# CITY OF ALBUQUERQUE

RE: **614 First Street Parking Lot Improvements** File: **J14-D016**  
Grading & Drainage Plan for Grading and Paving Permit, and SO-19  
PE Stamp: **5-1-2014**

Based upon the information provided in your submittal received 5/5/14, the subject Grading and Drainage Plan is approved for Grading Permit, Paving Permit, and SO-19.

GRADING AND DRAINAGE PLAN

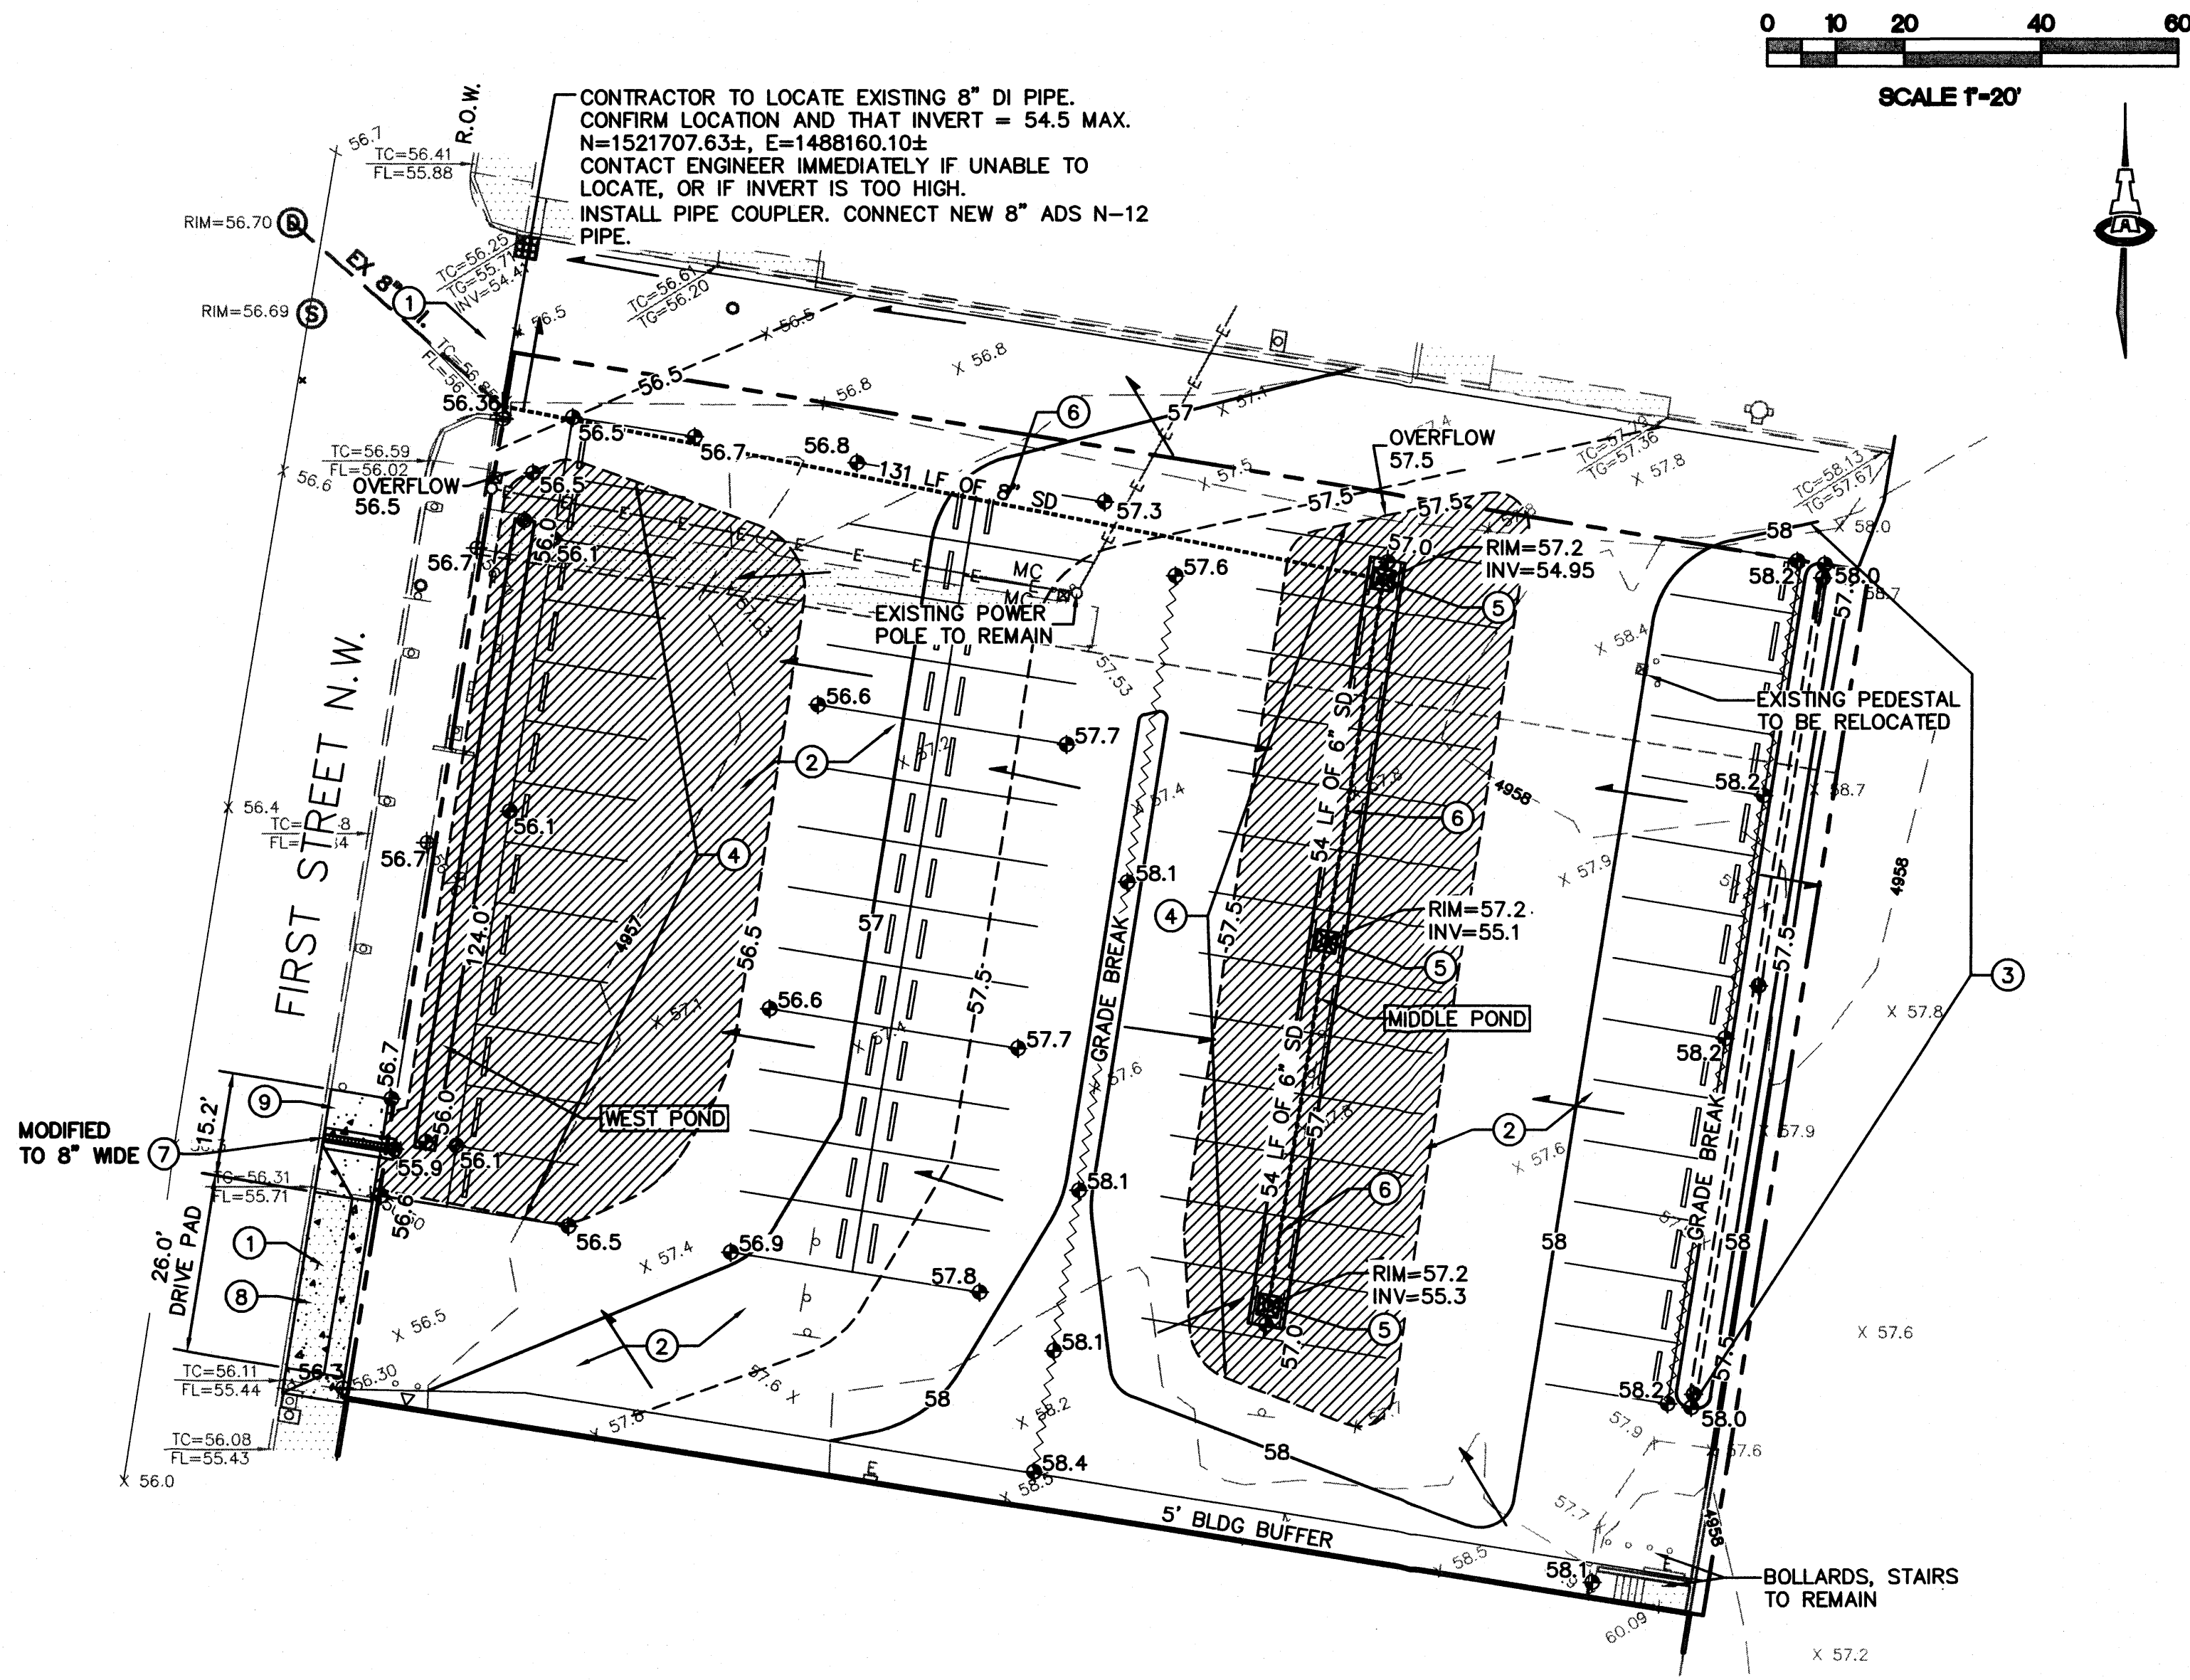
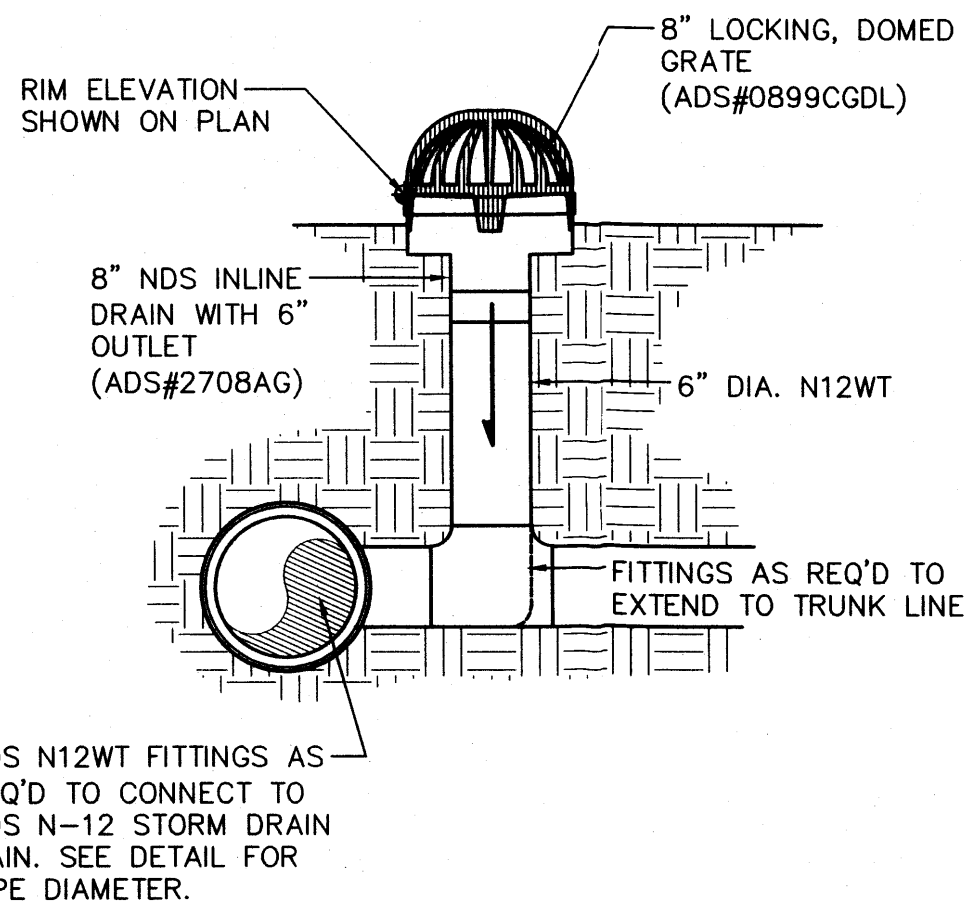
In response to your phone message, we would prefer to see the 8" wide sidewalk culvert. Curtis noted that the plan should VERY CLEARLY STATE that it needs to be only 8" wide, or they will automatically build 12" in the field.

Does the ADS pipe need to go up to 8" to balance the east pond flows?

1. Remove Key Note 5 from the existing inlet, and
2. Show the existing line from the existing (N) inlet to the manhole in First Street

1. Show on the plan the location (known or believed) for the existing storm drain lines in First Street, the particularly the proposed outfall for the east middle pond.
2. Dimension the expected location of the existing 8" DI pipe at NW entrance.
3. Build note 5 should be removed from the existing inlet on the north side of the NW entrance.
4. Build Notes 8 & 9 are reversed on the plan at the SW entrance.
5. Extend the sidewalk culvert 2' beyond back of sidewalk, and add the note to weld the bolts to the plate.
6. Site calculations assume detention in the onsite ponds. Provide calculations and the necessary restriction details to demonstrate that the two ponds only discharge 1.96 cfs, or about 0.98 cfs each.

*0.4 from east pond, but  
1.2 from west pond is too high*

1. This plan shows 50% treatment C, which may be applicable if the lot is to remain "Gravel Surfacing," however, if the owner is considering later installing an impervious surface, it would be prudent to size the ponds for that condition.

2. What runoff drains to the eastern pond?
3. The center pond is used to calculate detention at the 2.75 cfs rate. What is the release rate assumed through the gravel trench drain?

4. The broken sidewalk and driveways on First Street should be removed and replaced to current city standards.
5. Provide documentation of access and drainage easement rights on the north side of vacated Fruit St R/W.

6. Provide documentation of owner concurrence with the construction on the north side of vacate Fruit St. which is not part of this site.
7. Regarding the existing inlet being moved to First St R/W, Curtis is in agreement that this work may be done with as part of an S.O.-19, however, this plan will need to provide more detail of where the R/W line is located and how the type "D" inlet will be reconstructed without impacting site runoff and ADA access along First St. The proposed location will conflict with ADA access the north.

8. An alternate notion is the possibility of the old 8" drain to the ESE return of First and Fruit still being available to drain the site to the MH in First St.

9. See attached copy of Tom Isaacson's Grading Plan/Survey from 1982.
10. Clearly label the site property line.
